**KIRKLEES METROPOLITAN COUNCIL
INVESTMENT & REGENERATION SERVICE**

DELEGATED DECISION TO DETERMINE PLANNING APPLICATIONS

Reference No: 2019/62/90734/W

Site Address: 38 , Longden Avenue, Beaumont Park, Huddersfield,
HD4 5JE

38 LONGDEN AVENUE
 BEAUMONT PARK HUDDERSFIELD
 DRG NO 1849·5c SCALE 1·50

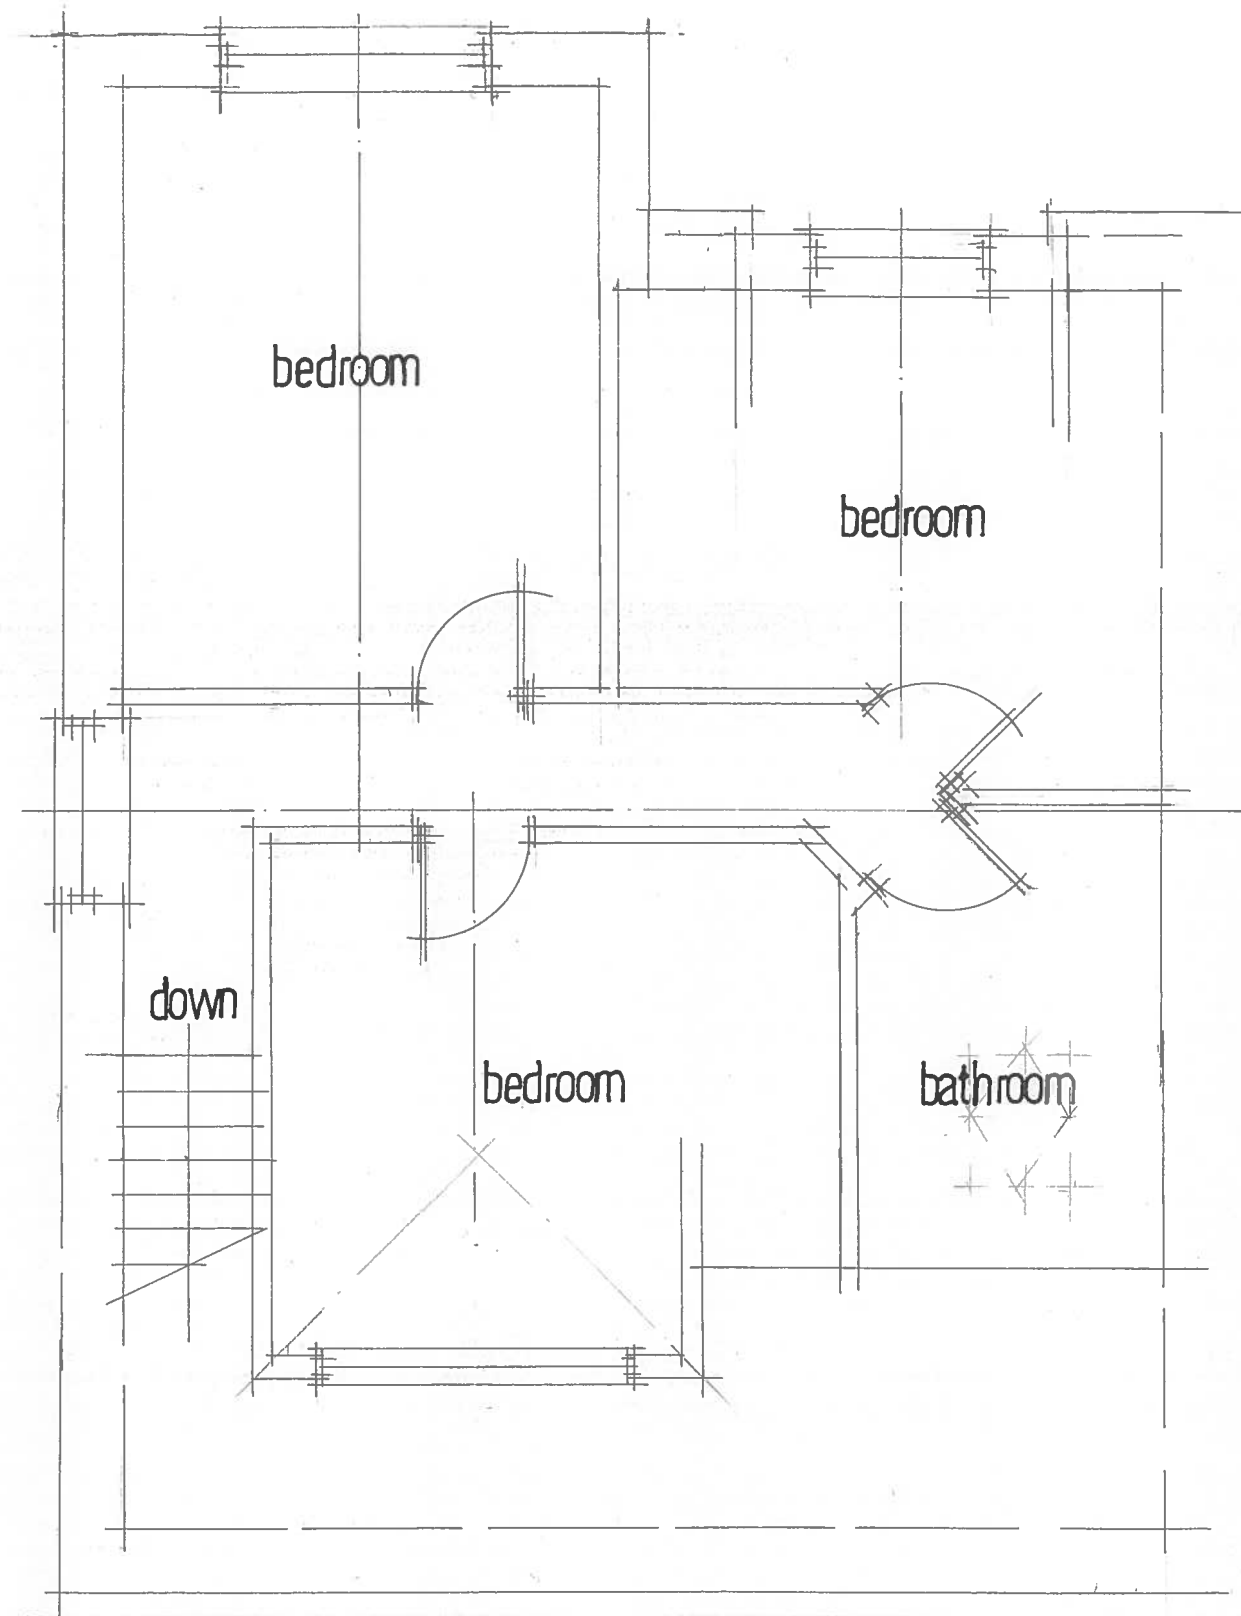
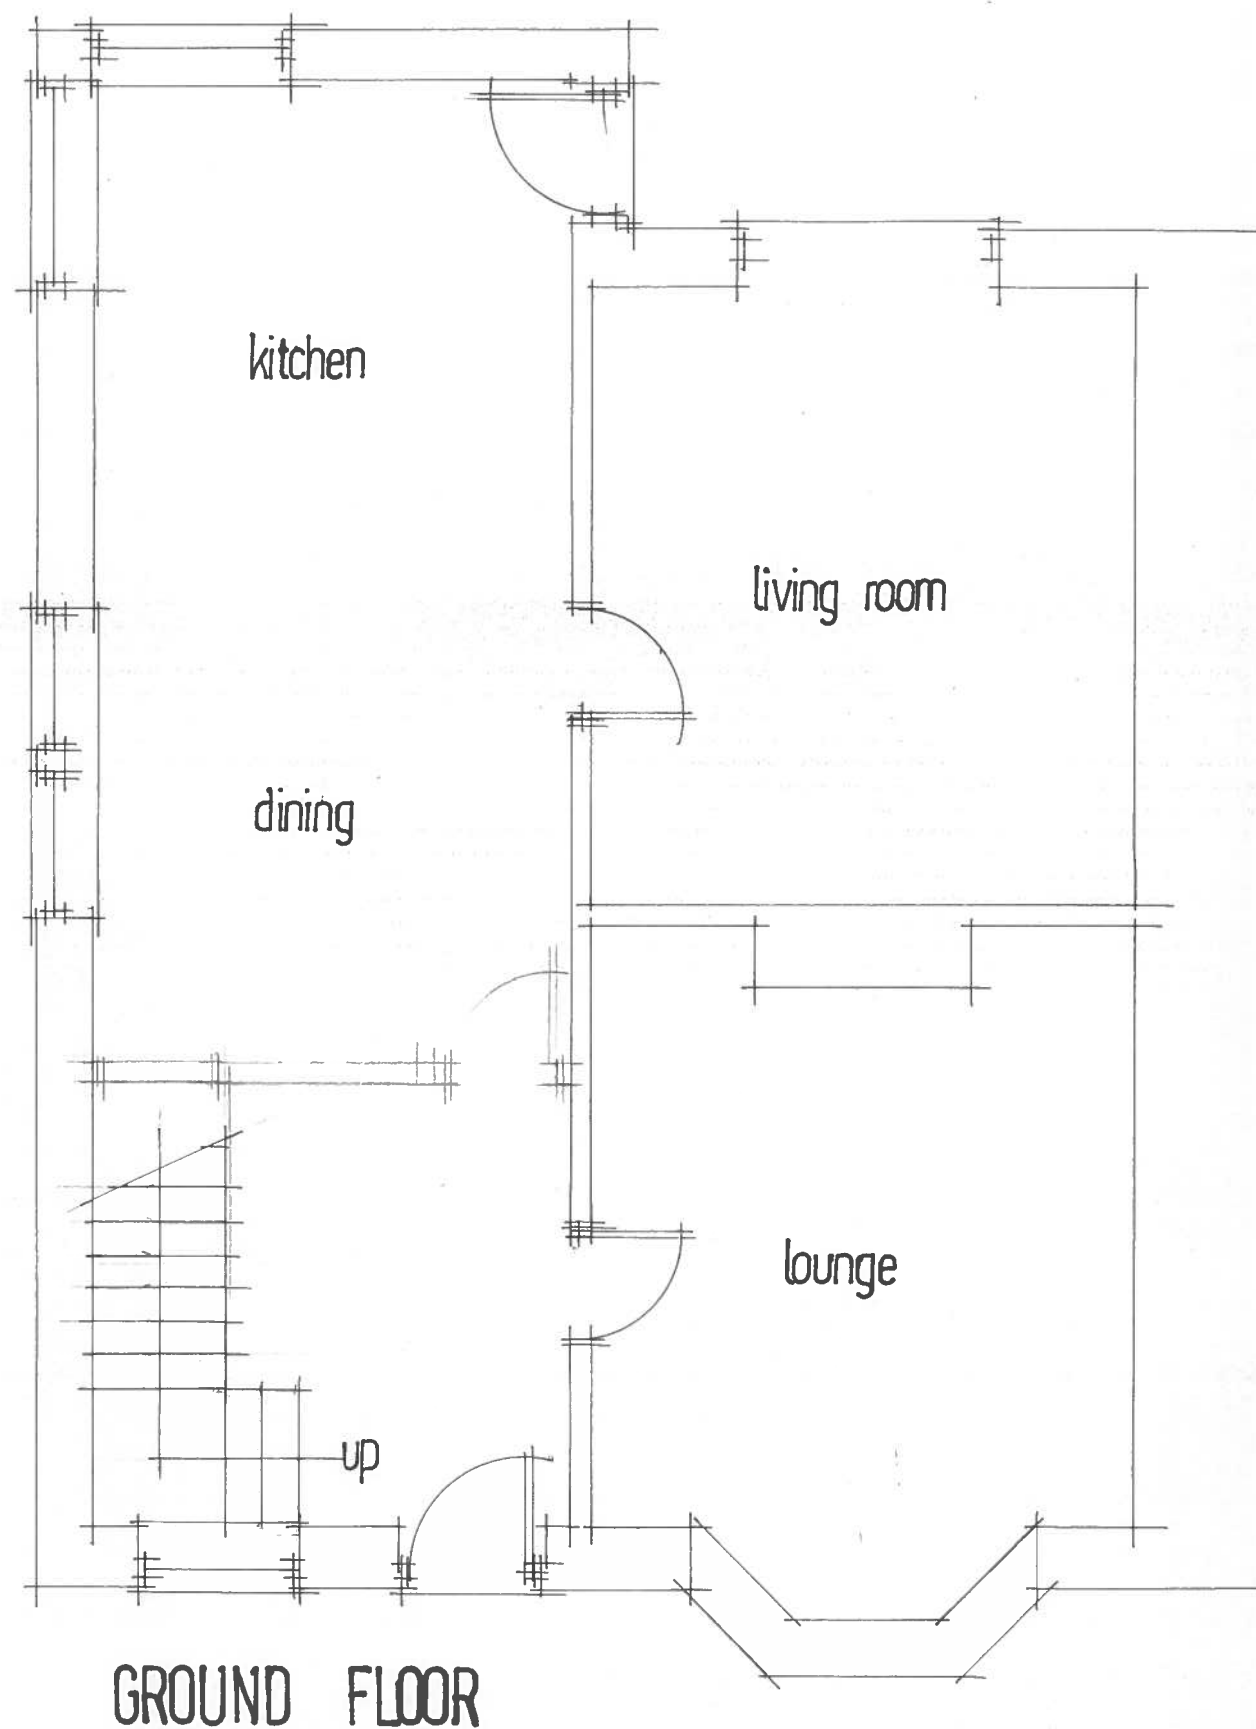
1 The proposed first floor rear extension, by reason of its siting, scale and design, would fail to respect the character and appearance of the host building or the surrounding area. This element of the proposal would result in a disproportionate and incongruous addition to the original dwelling. To approve the development would be contrary to Policy LP24 (a,c) of the Kirklees Local Plan and Chapter 12 of the National Planning Policy Framework.
